**Application by Keuper Gas Storage Limited**

**Keuper Gas Storage Project (EN030002)**

**The Examining Authority's first written questions and requests for information**

**Issued on Wednesday 23 March 2016**

WHITLEY PUMPING STATION - KGSP - ELEVATIONS

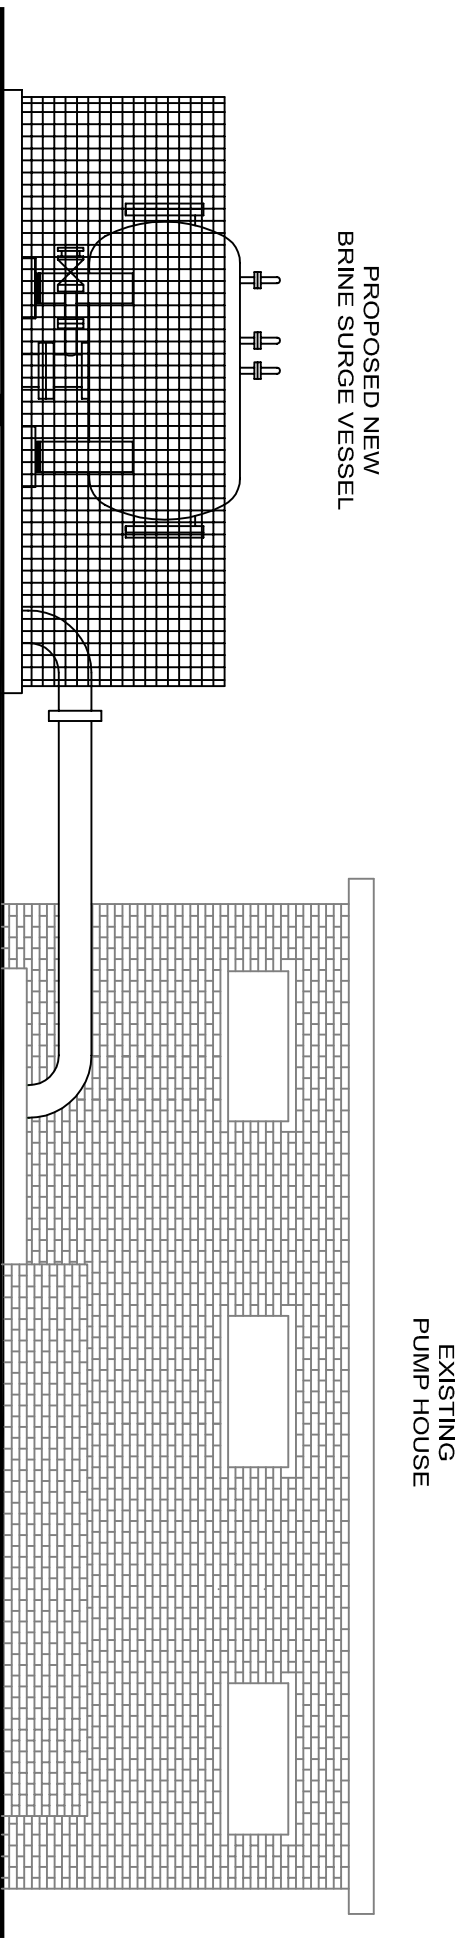
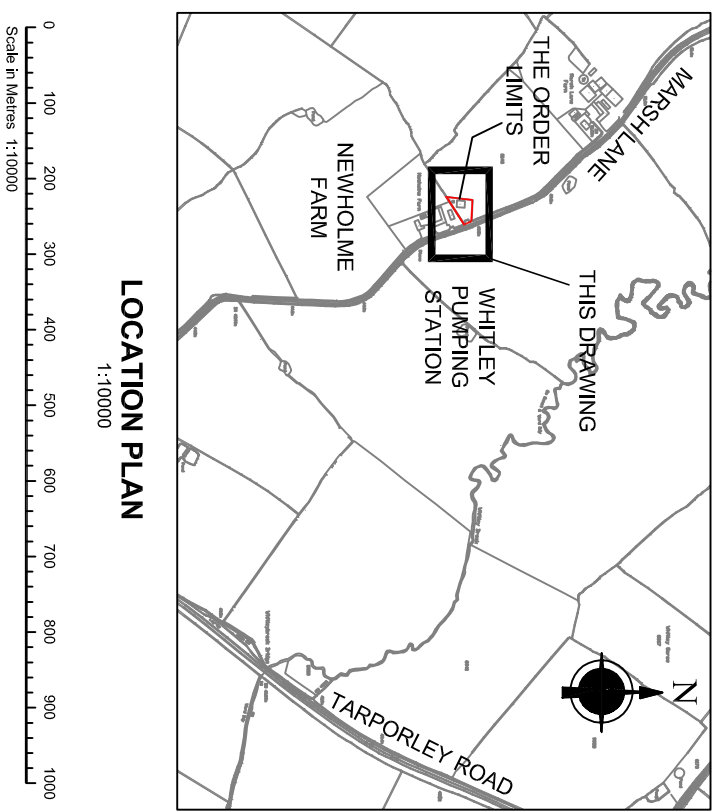
3.35	Applicant, Cheshire West and Chester Council	<p>Whitley Pumping Station and Runcorn Outfall</p> <p>Please confirm what sound pressure level would be achieved at the façade of the pumping station. Please can Cheshire West and Chester Council confirm what specified noise emission limit should be achieved at the façade of Whitley Pumping Station and secured in the DCO.</p> <p><b>CWAC Response: For operational noise the Council would normally require that the rated noise level is 5dB below the background as measured in accordance with BS4142:2014 when measured at the façade of the nearest noise sensitive receptor. In cases where background noise levels are low then the Council would not expect the rated noise level to be lower than 30dB.</b></p>
